**Application for Planning Permission for Works or Extension to a Dwelling**

**Development:** Conversion of existing garage to habitable room and lifting of flat to accommodate headroom  
**Location:** 10 Lodge Close Ancton Middleton-On-Sea PO22 6NF

title
Proposed Block Plan

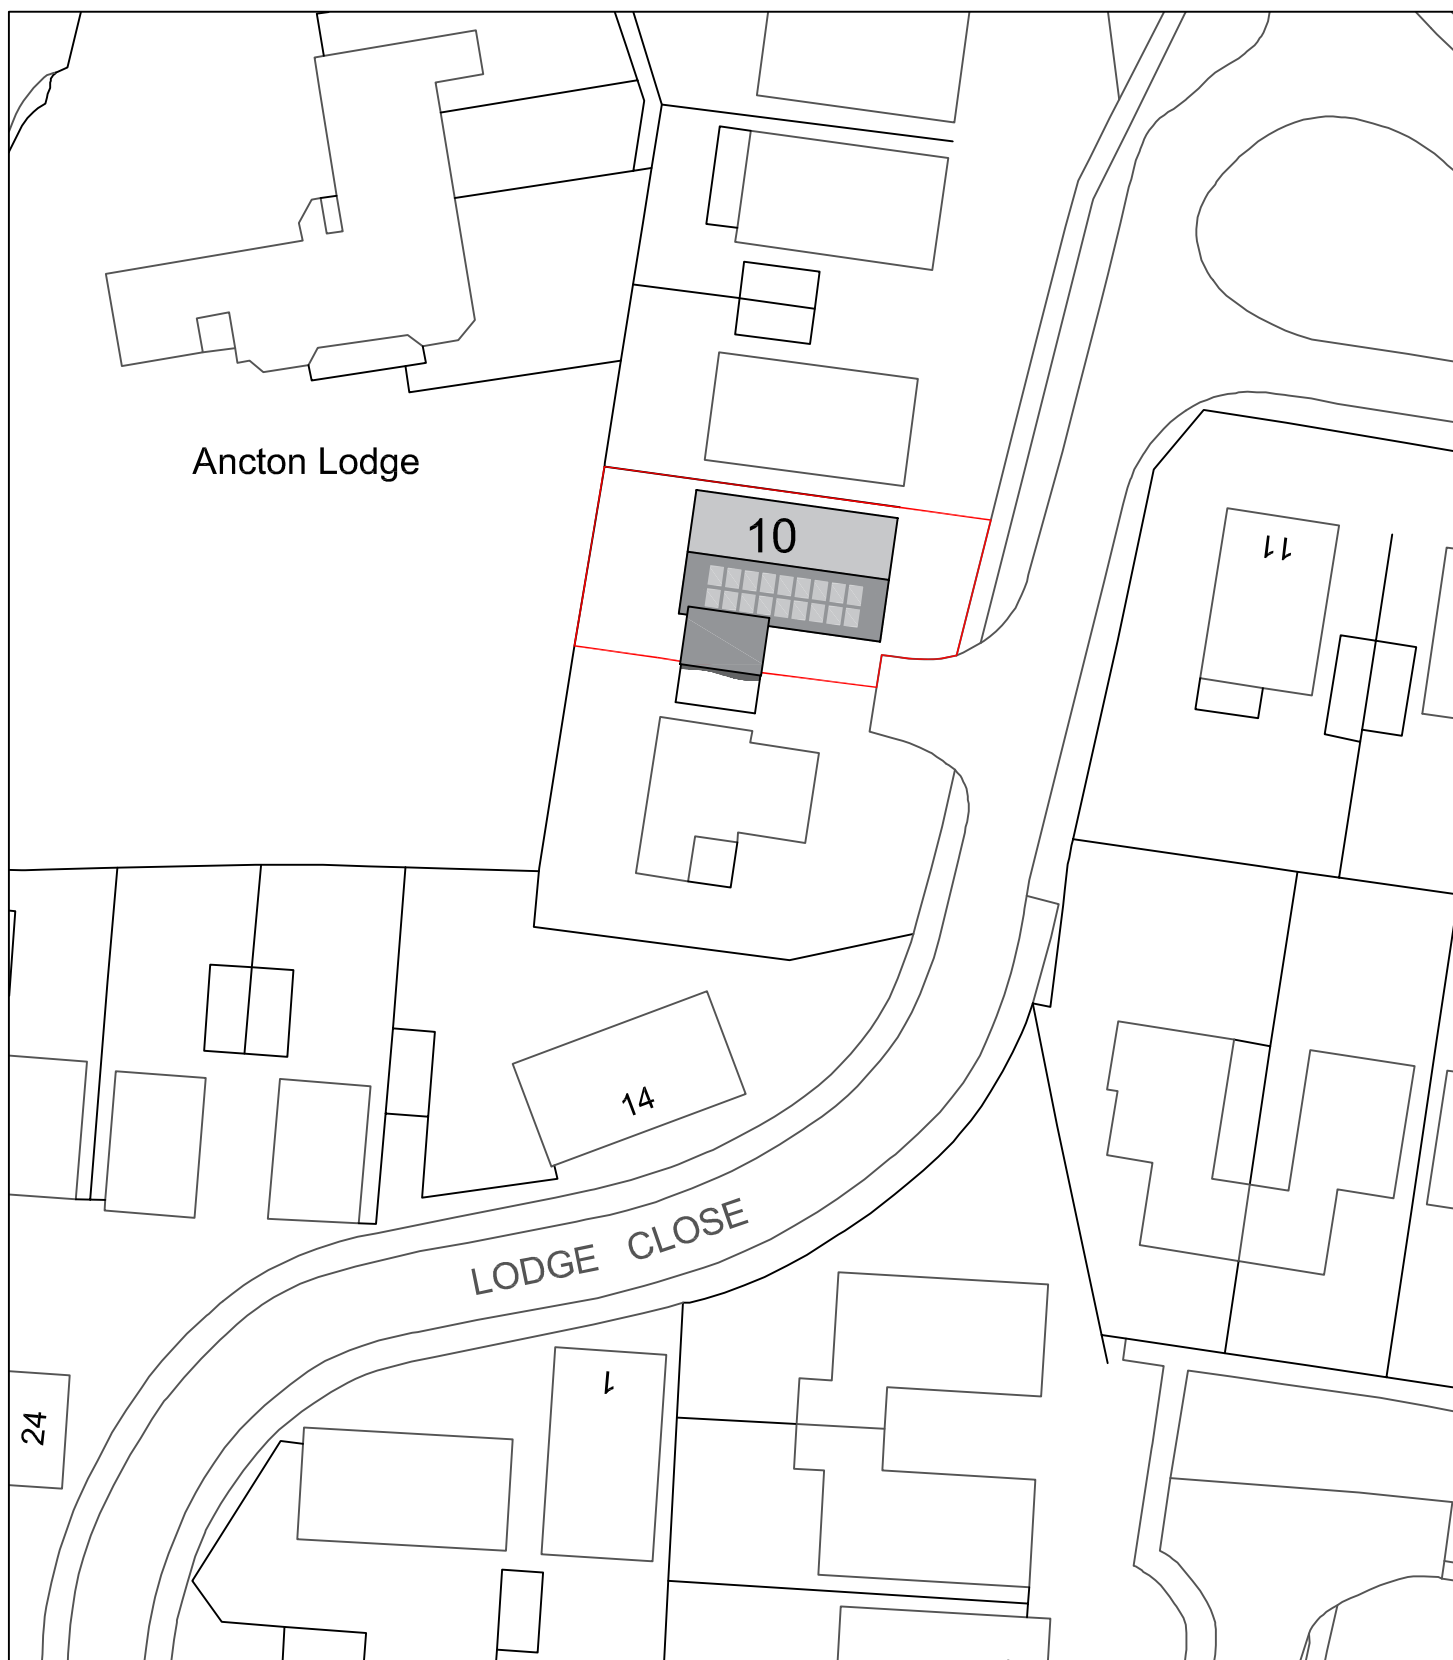
Dimensions: You are required to include dimensions from the proposed extension/alteration to all site boundaries. Please amend

title
Existing Location Plan

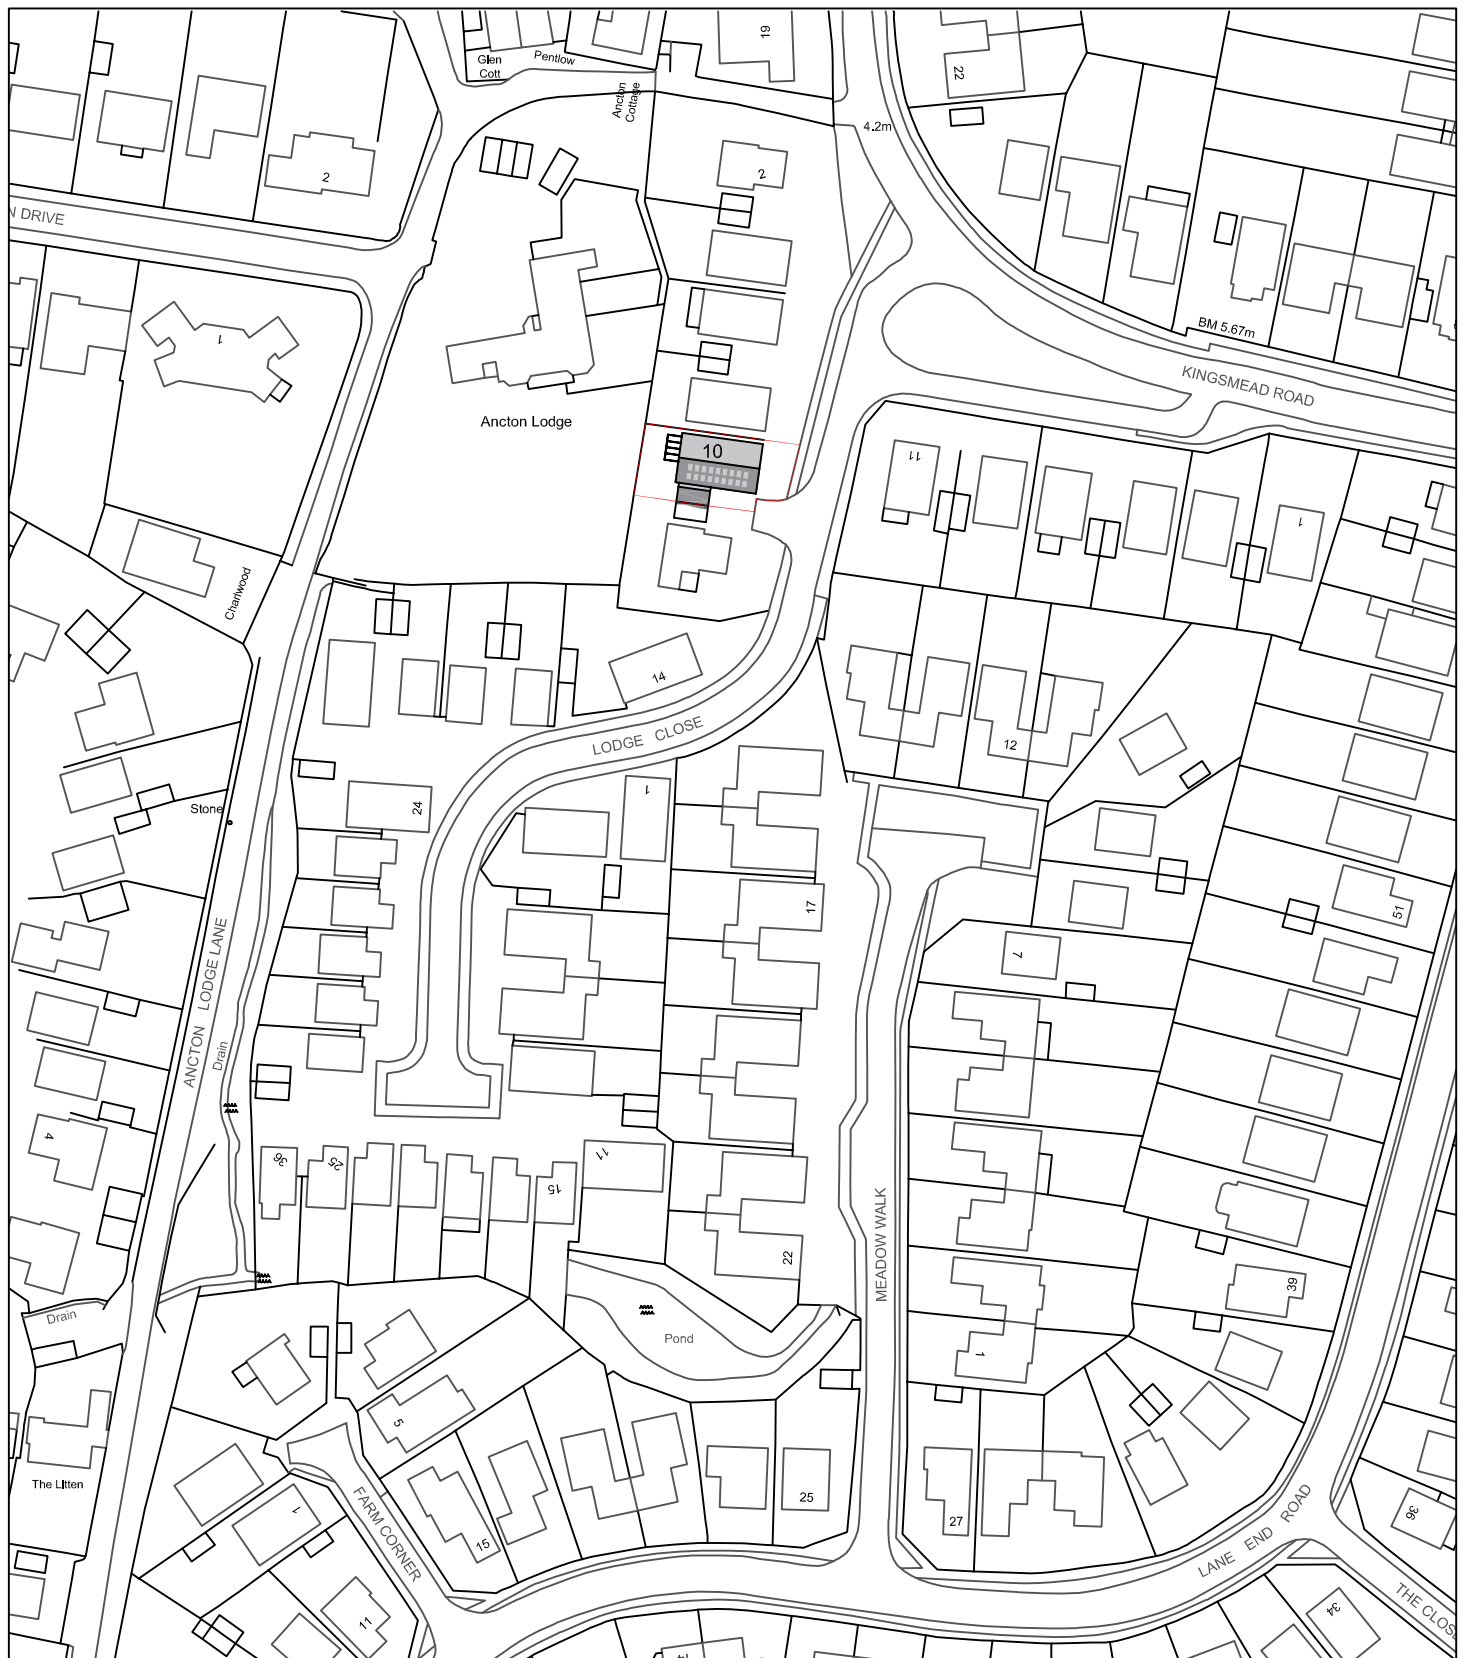
Location Plan: You are required to include a rear outline around the entire site on the location plan.
